**Consultation Response from KC,
Ecology Unit**

2026/91599 Wesley House, Huddersfield Road, Birstall, Batley, WF17 9AZ

Discharge of details reserved by conditions 3 (roof light), 8 (bin store), 9 (lighting), 10 (bat box), 11 (Construction Management Plan - Gravestone) on previous permission 2024/92105 for alterations to convert former offices to 21 apartments (Listed Building within a Conservation Area)

Date Responded: 18/06/2026

**Planning Approval Ref :** 2024/62/92105/E  
**Condition 9 – External Lighting**

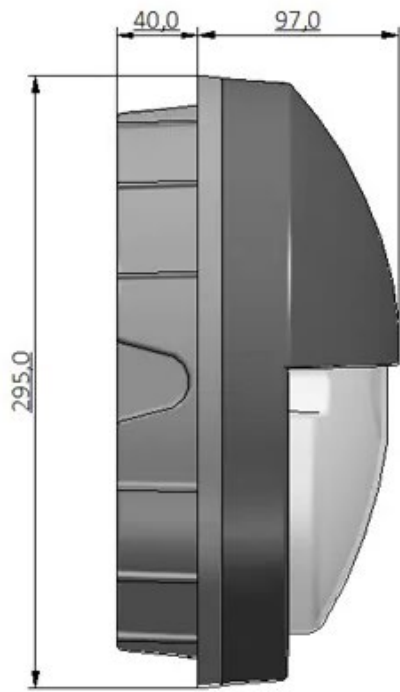
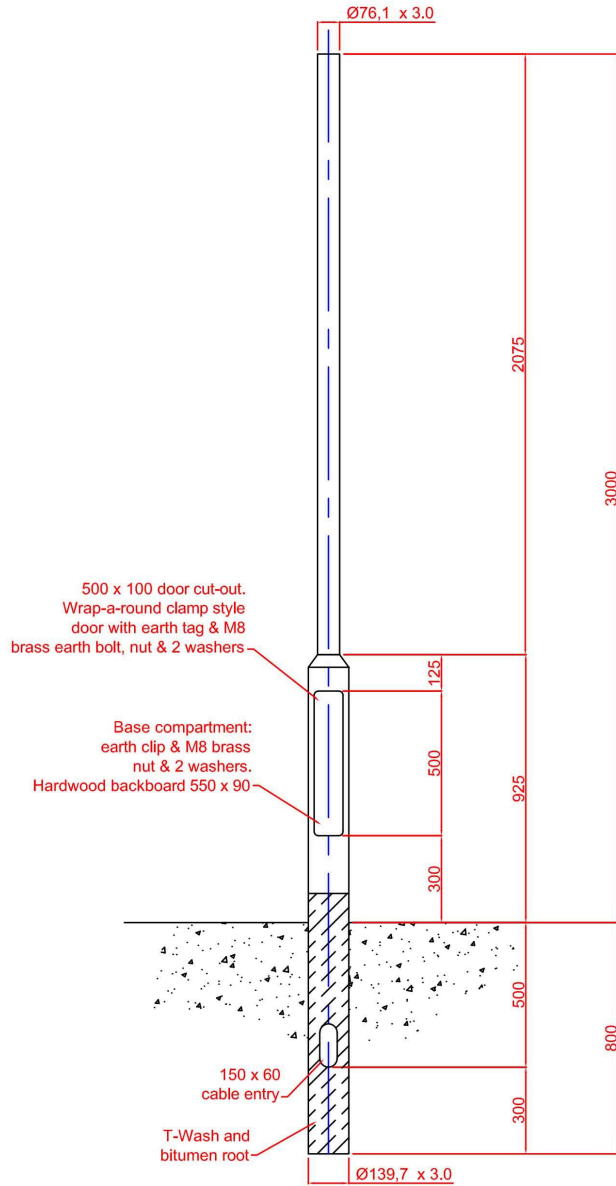
The submitted information details that downlighting will be installed on the building, but does not detail where this will be installed, or what colour temperature it will be. I would recommend this information is provided, prior to discharge of condition 9.

Plan: **Proposed Site Layout and Location Plan**

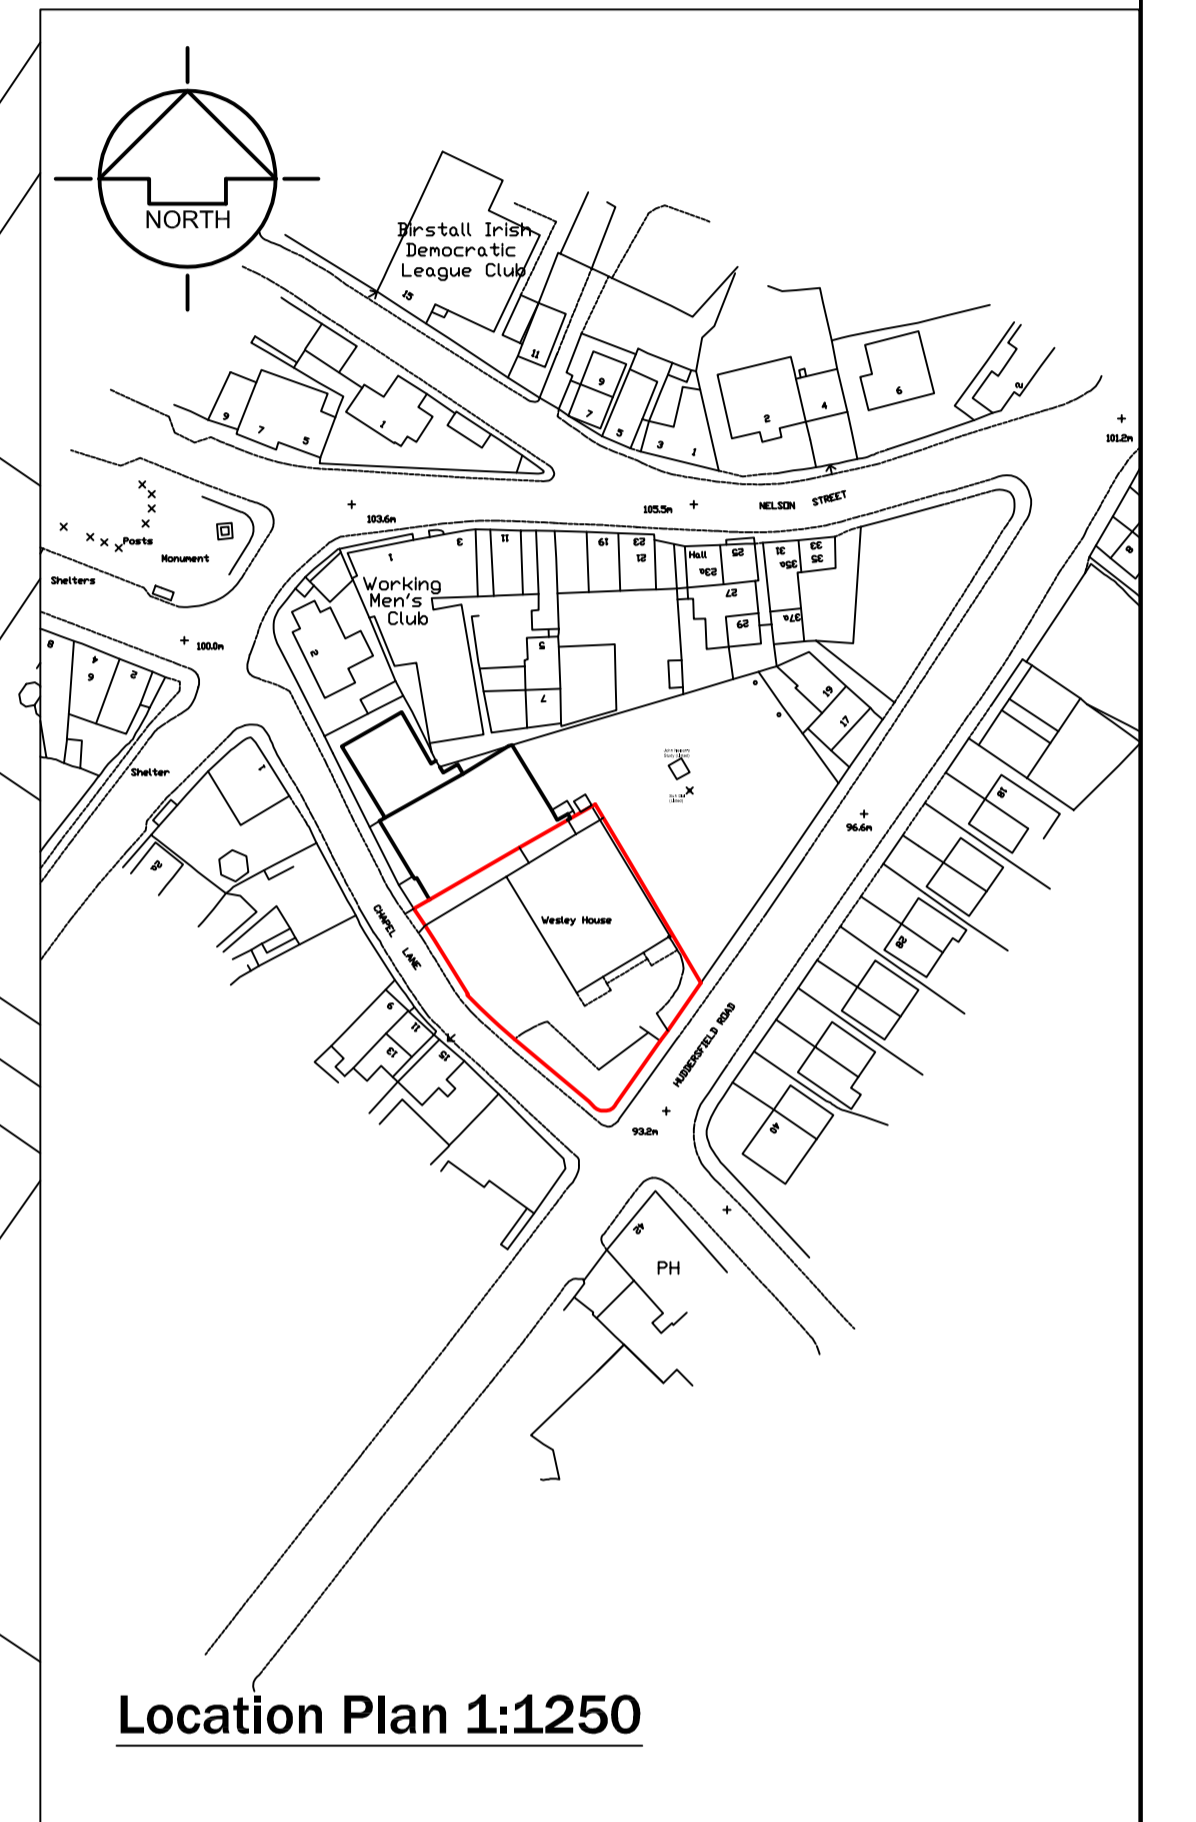
The documents submitted also show that a bat box will be installed on a retained tree. I'm satisfied that sufficient information is available for the discharge of condition 10.
